RE: Barnes Short Plat SP-12-00008

Thank you for the opportunity to comment on the Barnes Short Plat SP-12-00008

REVIEW OF THE APPLICATION FILE:

BARNES SHORT PLAT KITTITAS COUNTY SHORT PLAT NO. SP-12XXXXX A PORTION OF THE NE 1/4 SECTION 5, TOWNSHIP 16 NORTH, RANGE 20 EAST, W.M., KITTITAS COUNTY, WASHINGTON

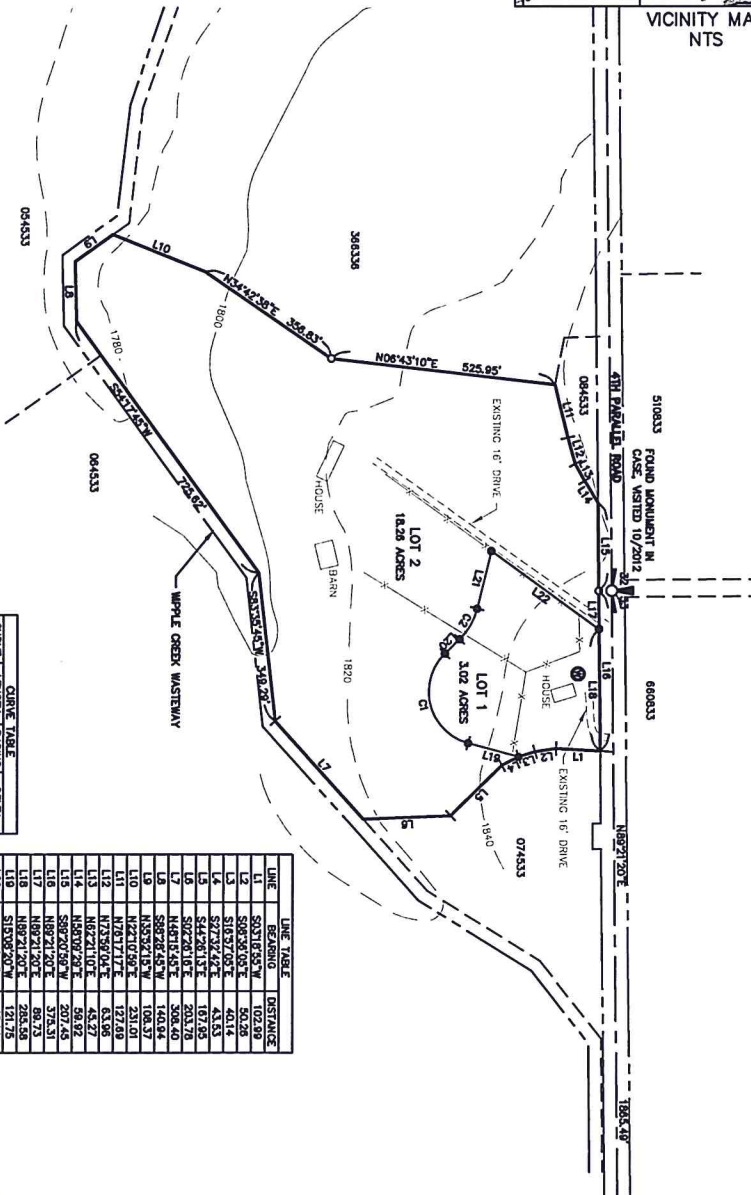
At this point in time this application, it appears that only lot 1 contains a well. If there is another well on lot 2, then that well needs to be identified on the plat map, and meet all adequate water supply requirements as mentioned above. If a shared well is in use, in addition to the adequate water supply requirements, a shared well users agreement will need to be recorded and submitted before KCPHD can recommend final approval. It also appears that both proposed lots have homes located on them. If both homes have permitted septic systems additional soil logs will not be required.
